NSIP Reference Name / Code: A46 Coventry Junctions (Walsgrave) / TR010066

Natural England's response to the submissions at deadline 3

Examining Authority's submission deadline 4 with a date of 22 July 2025

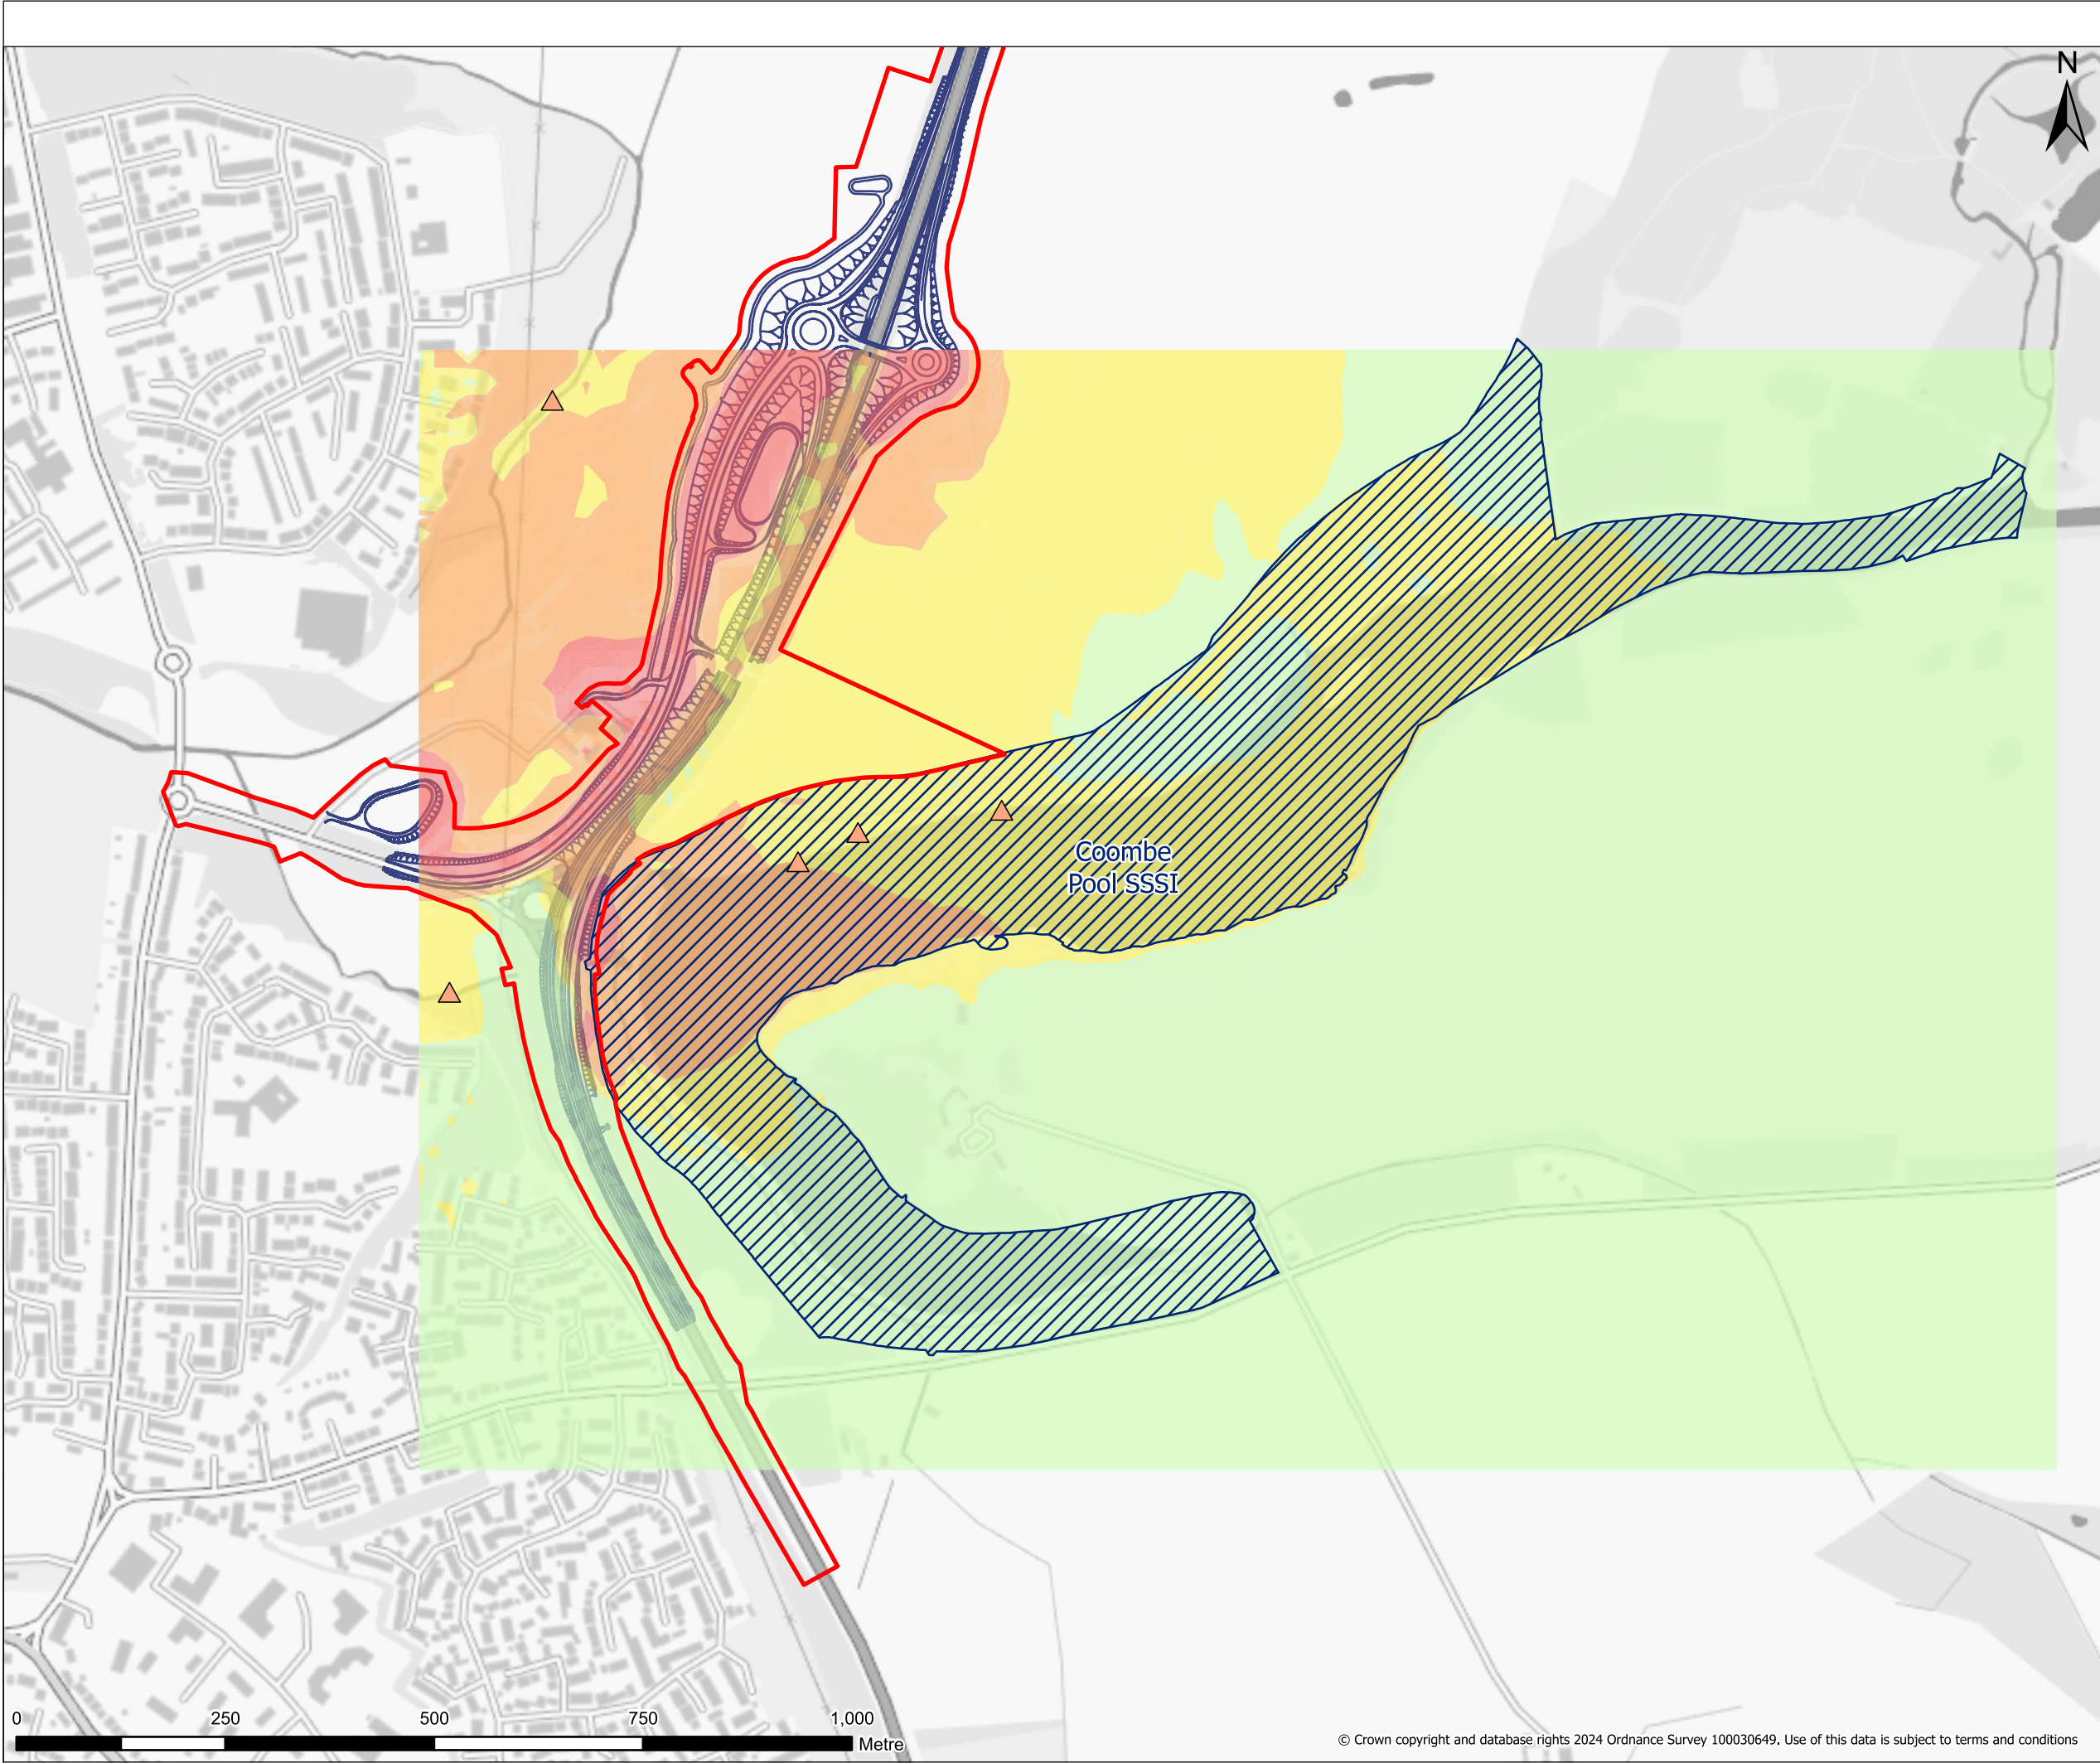
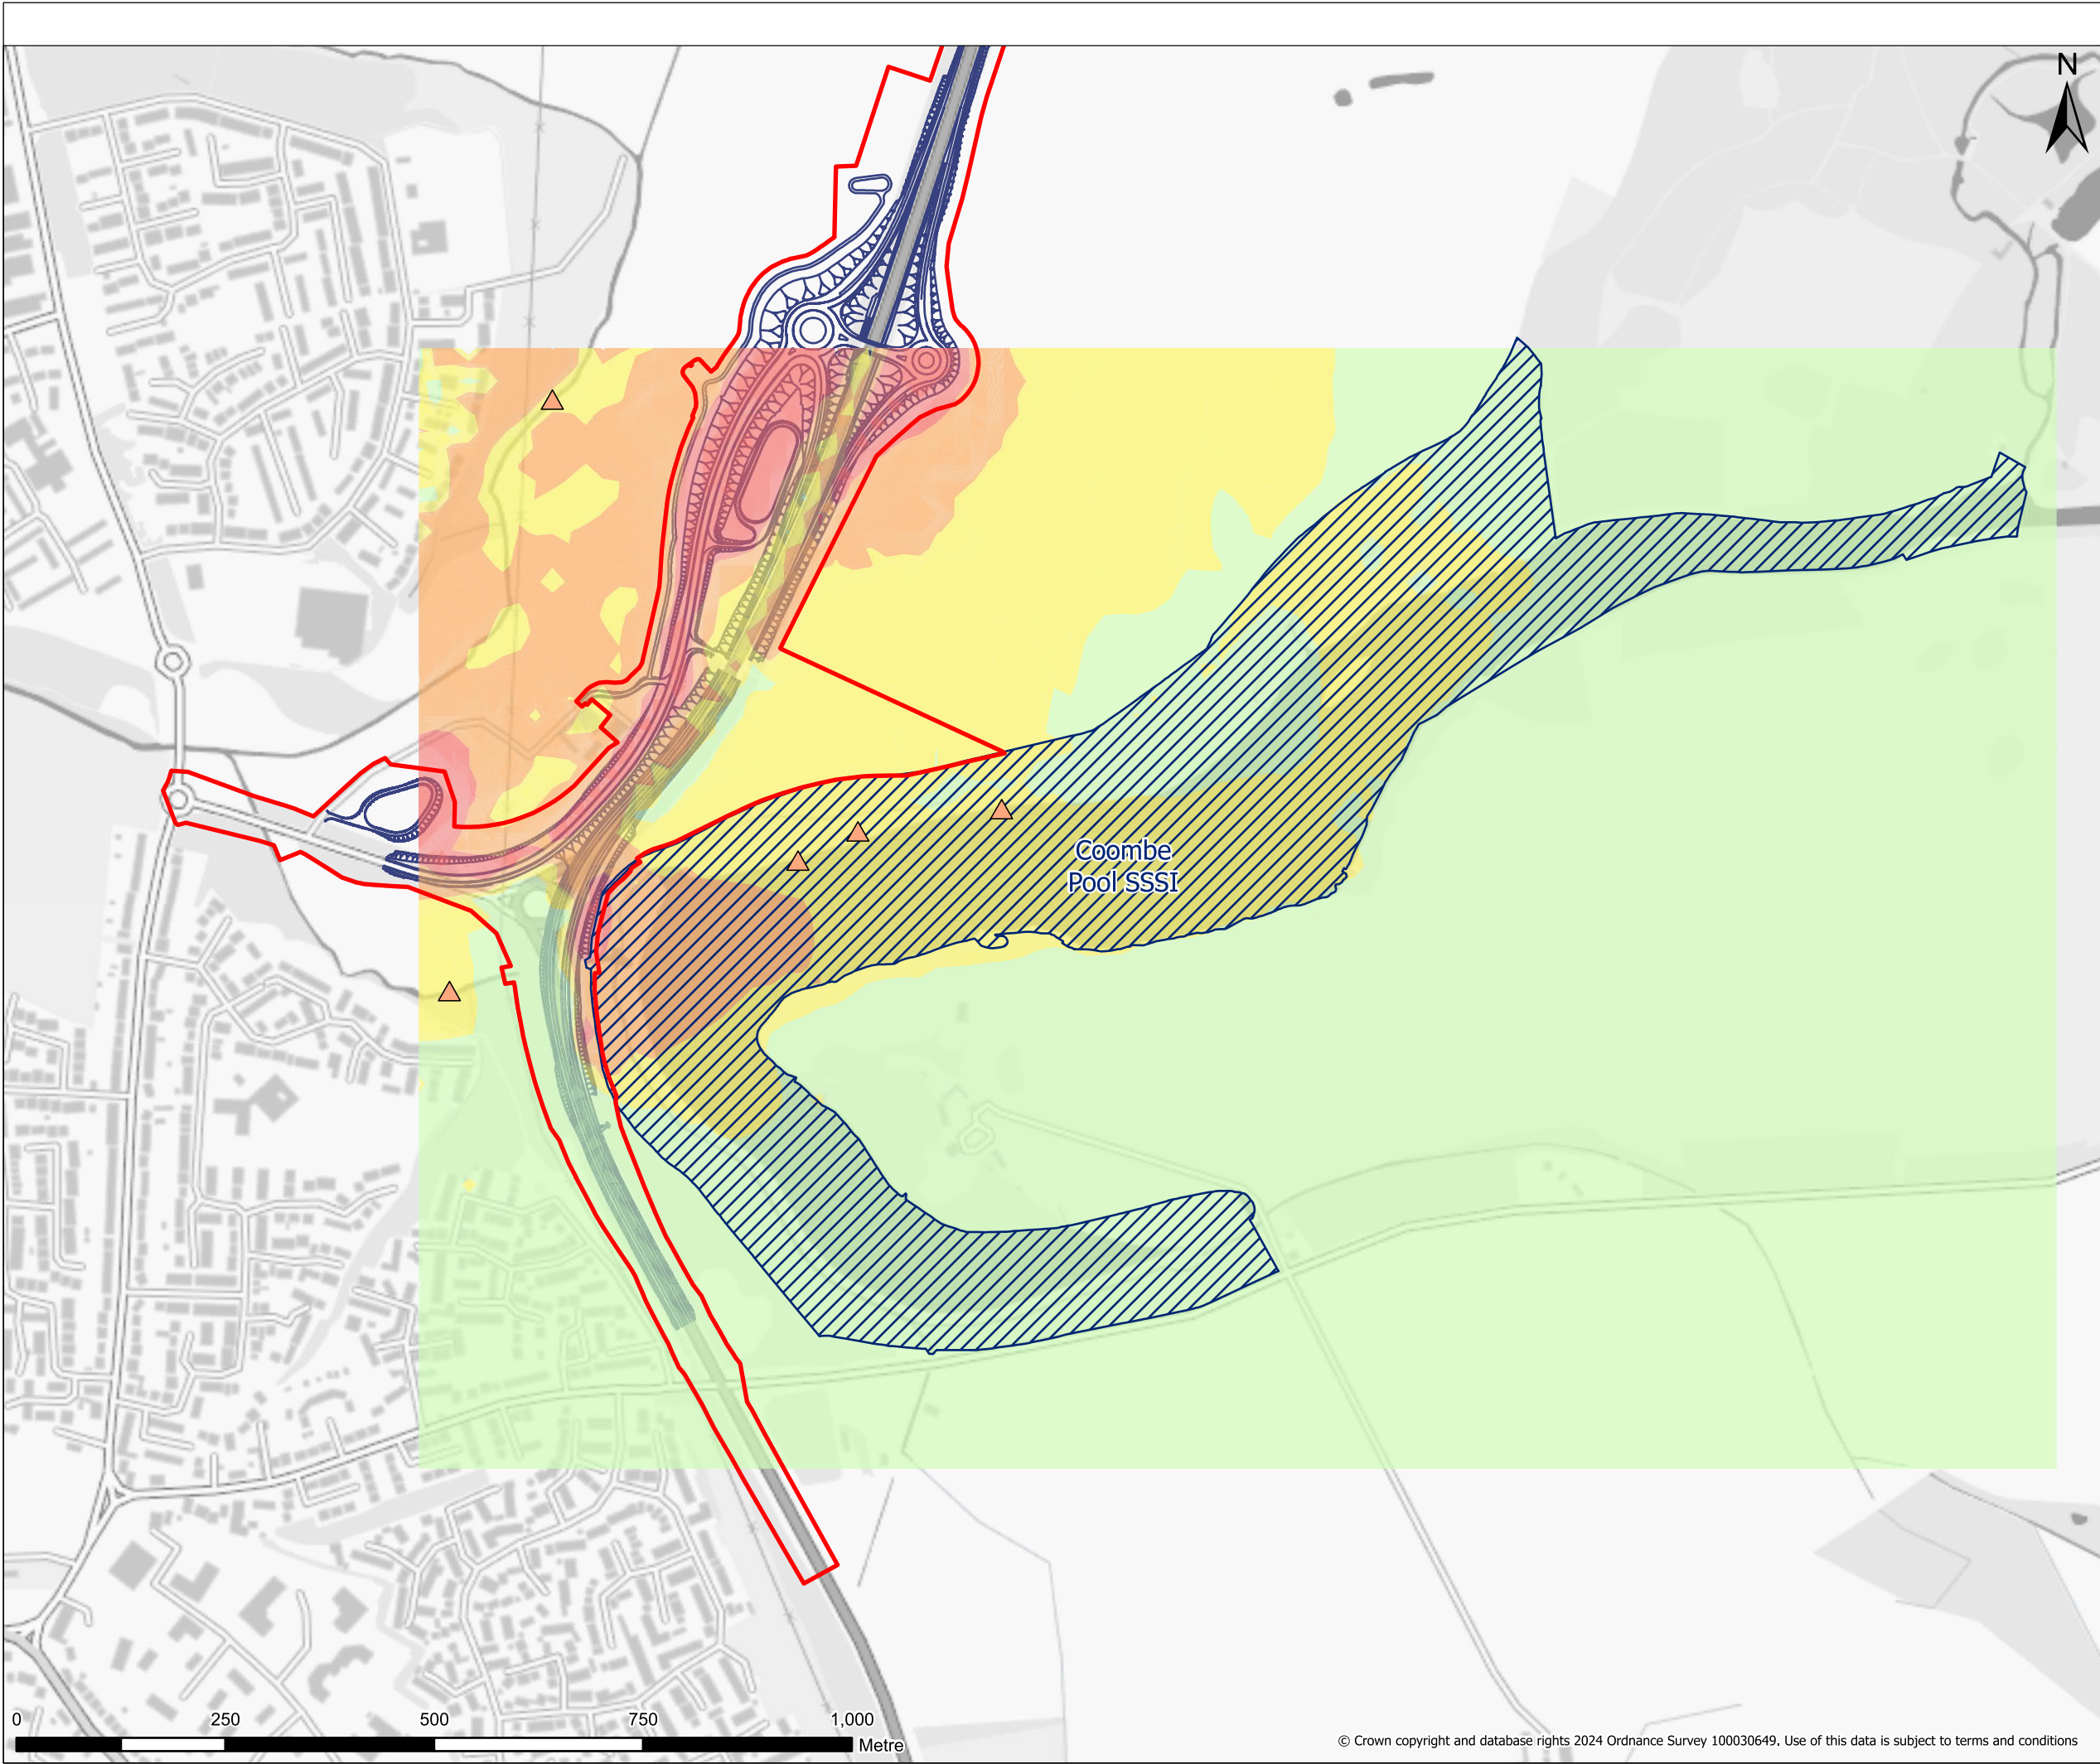
The latest submissions have provided some further information on the noise impacts. Construction noise will result in noise levels above 3dB even with a 2m noise barrier (see Table 1 below) which will impact on breeding waterbirds, wintering waterbirds (including Shoveler) and woodland breeding and wintering within Combe Pool SSSI. There will be an increase in noise levels above 3dB for a portion of the SSSI and a decrease of -1.0dB or less during operation. The modelled background noise levels at the closest edge of the lake to the Order boundary in the do minimum scenario for 2028 will be 61.5dB and 64dB for 2028 if the scheme goes ahead.

From the information provided it appears that the construction noise impacts will not be fully mitigated, and a residual impact remains. We therefore advise that the proposal should include the provision of a permanent noise barrier to mitigate for residual operational noise impacts on breeding and wintering birds.

Traffic is predicted to continue to increase over time (Source: [National road traffic projections 2022](#)) and it is likely that noise levels within the SSSI will also continue to increase for the operational stage of this road scheme. Low woodland breeding and wintering bird numbers have already been identified, which the Applicant partly attributes to the proximity of the existing road (2.1.24 REP3-028).
